# CITY OF ALBUQUERQUE

January 20, 2006

**Re: African American Cultural Center, State Fair Grounds  
Grading and Drainage Plan  
Engineer's Stamp dated (None) (K18-D94)**

C100 GRADING PLAN
1"=20'-0"

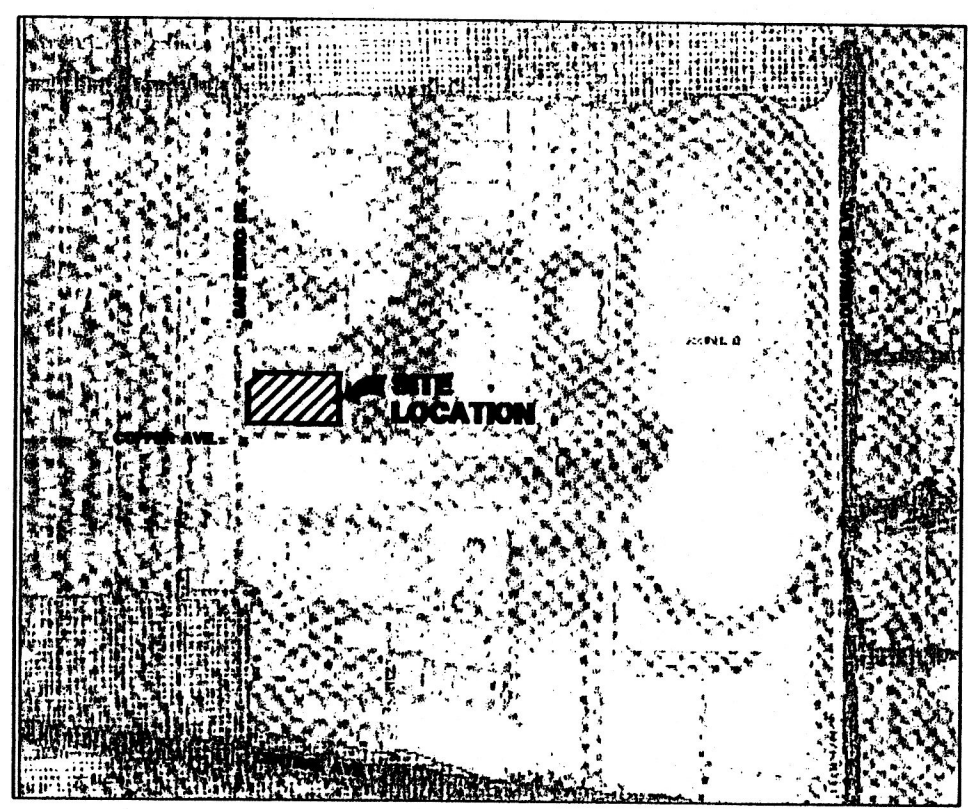
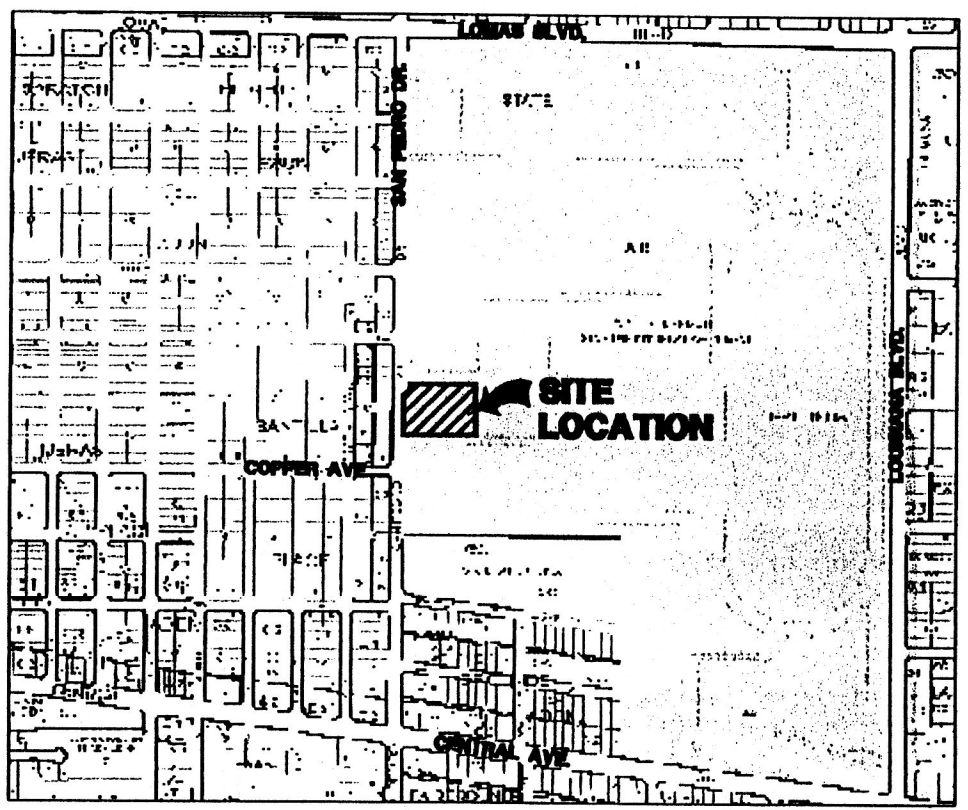
1. The plan needs to be stamped and dated by a State approved Professional Engineer.
2. Hydrology calculations are needed.
3. This plan needs to follow the Master Drainage Plan for the storm drain in San Pedro.
4. How are you connecting the 12" RCP to the San Pedro SD?
5. Which direction will the new roof drain?
